Application # 0750018224R

Re: Status of Improvement Permit Application #07-5-18224

Lot 196
CRESTVIEW

07-50018224  
Lot 196  
Construction

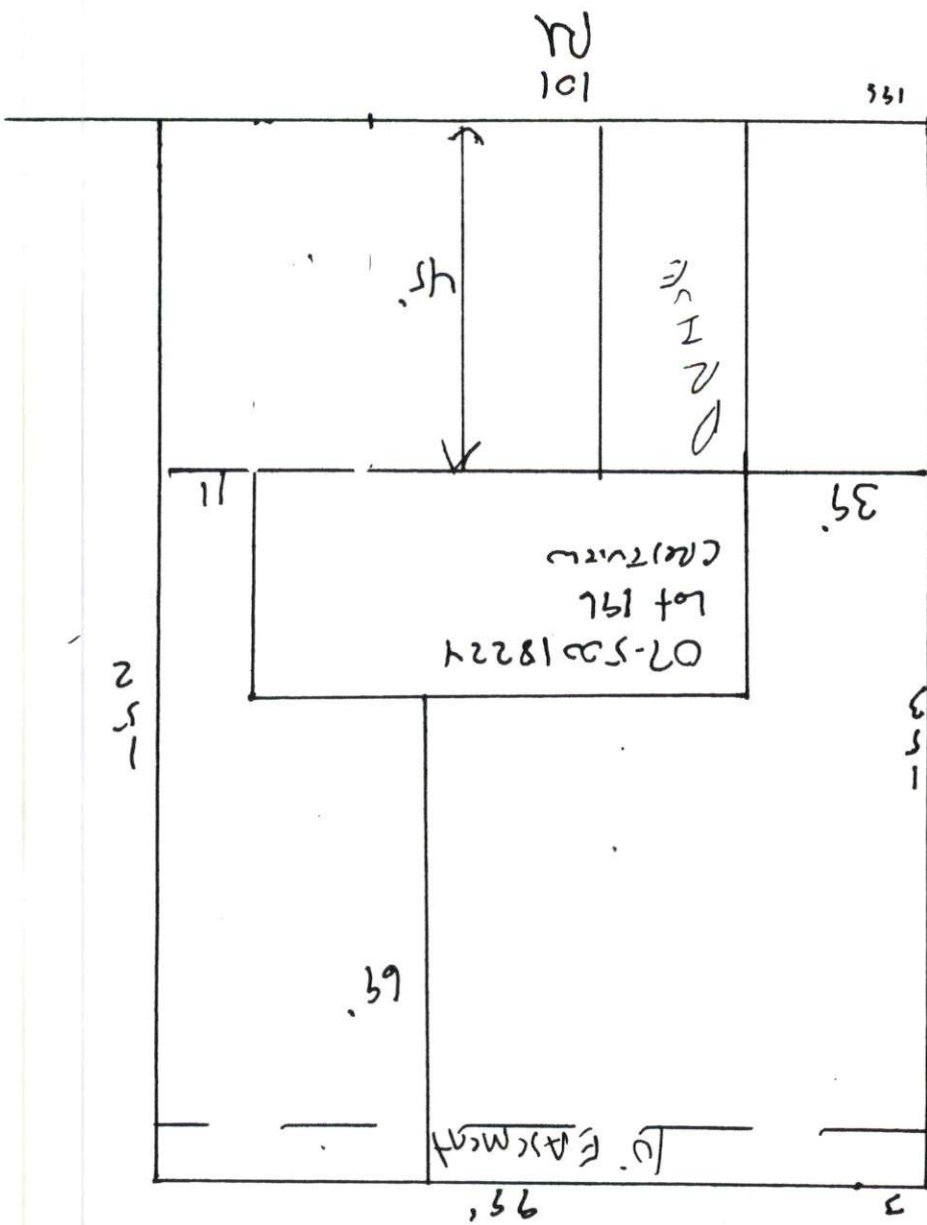
- 1. Property lines/corners not marked or labeled
- 2. House corners not marked or labeled
- 3. Directions not clear to property
- 4. Property needs brush or vegetation removed
- 5. Backhoe pits required
- 6. Other – Move house as shown and submit new plot plan to Central Permitting.

Required Residential Property Line Setbacks: Comments: 8/28 move home per EH
